# KITTITAS COUNTY

### MEMORANDUM

SUBJECT: Blue Sky Short Plat SP-10-00003

#### The following shall be conditions of preliminary approval:

BLUE SKY SHORT PLAT
A PORTION OF THE SOUTH 1/2 OF SEC. 29 T.20N., R.16E., W.M.
KITITAS COUNTY, WASHINGTON

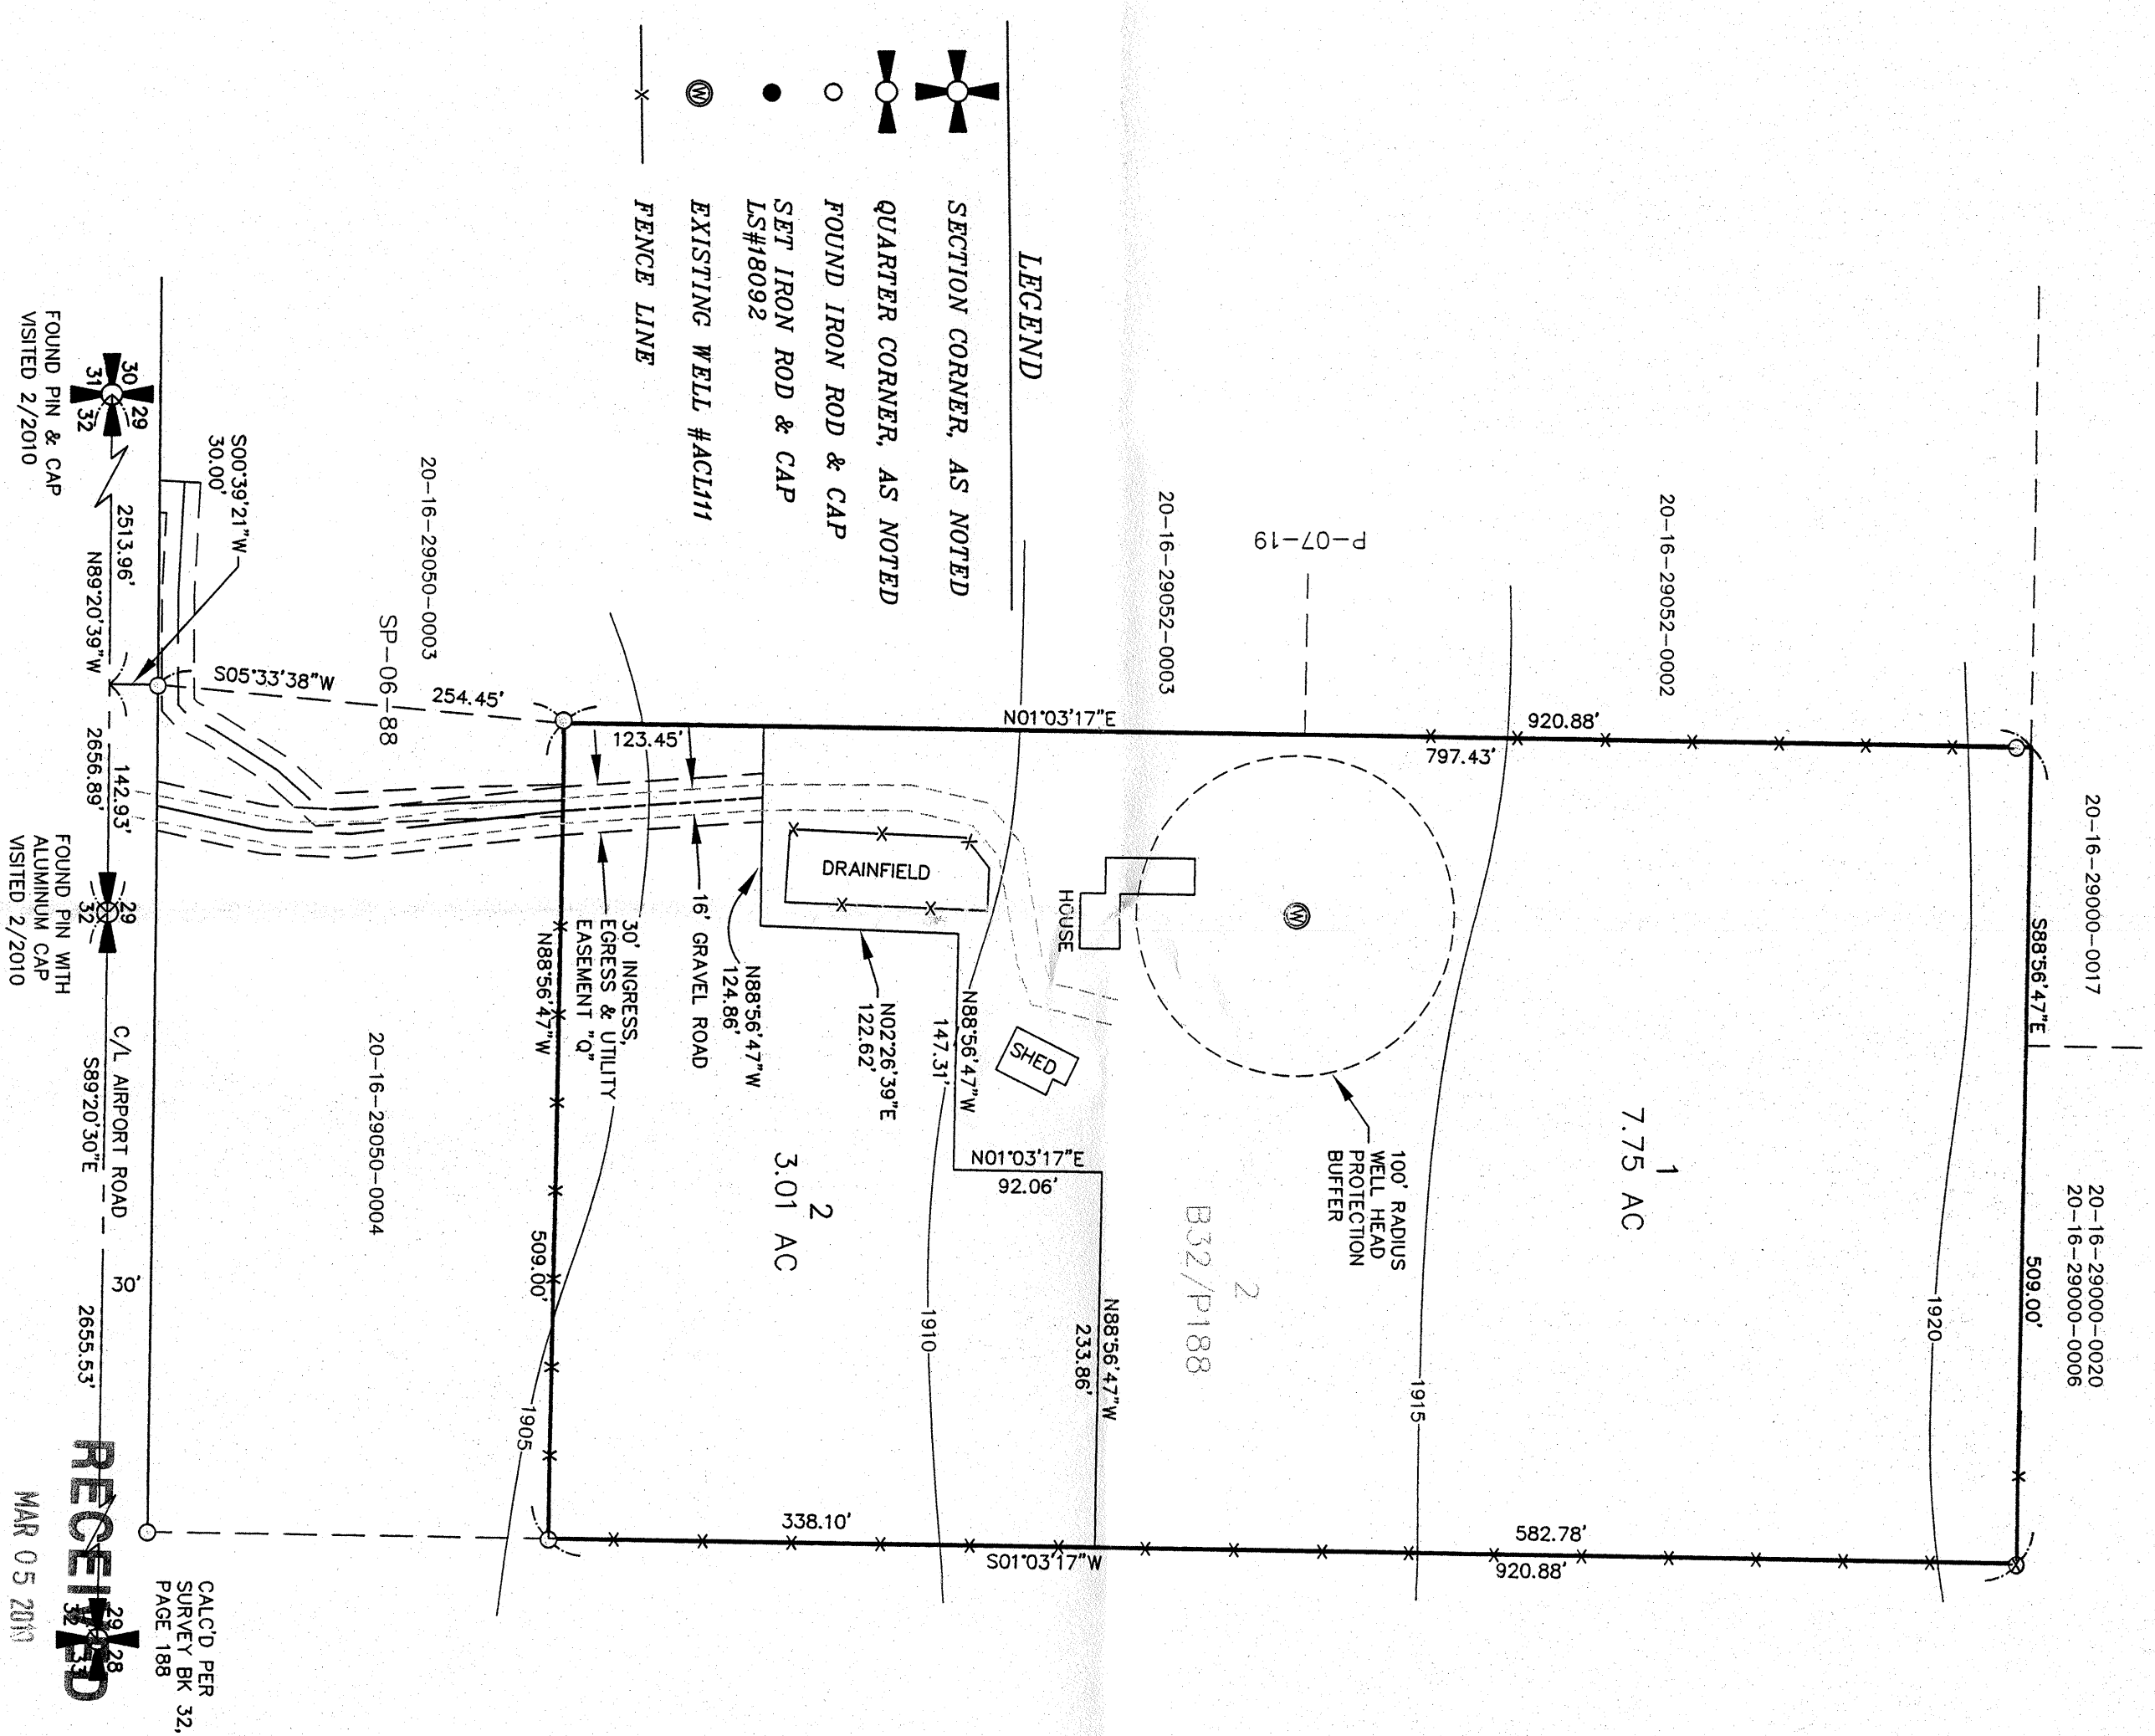
3. Variance: All conditions of Road Variance 09-10 shall be met, including the construction of a paved apron, 22' wide gravel road, and all other road standards requirements.

4. Private Road Improvements: Access from Airport Road to the cul-de-sac shall be constructed to meet or exceed the requirements of a High-Density Private Road that serves 3-14 tax parcels. See Kittitas County Road Standards, 9/6/05 edition.

- a. Access easements shall be a minimum of 40' wide. The roadway shall have a minimum width of 20', with 1' shoulders, for a total width of 22'.
  - b. Minimum centerline radius will be 60'.

- c. Surface requirement is for a minimum gravel surface depth of 6".
  - d. Maximum grade 8% flat, 12% rolling or mountainous.
  - e. Stopping site distance, reference AASHTO.

- j. All easements shall provide for AASHTO radius at the intersection with a county road.
  - k. A paved apron shall be constructed at the intersection of the proposed private intersection and the county road.

5. Cul-de-Sac: A cul-de-sac turn-around having an outside right-of-way or easement diameter of at least 110 feet shall be constructed at the closed end of all dead-end roads serving 3 or more lots. The driving surface shall be at least 96 feet in diameter. Cul-de-sacs must also conform to the requirements specified by the 2006 International Fire Code. Contact the Fire Marshal regarding any additional cul-de-sac requirements.
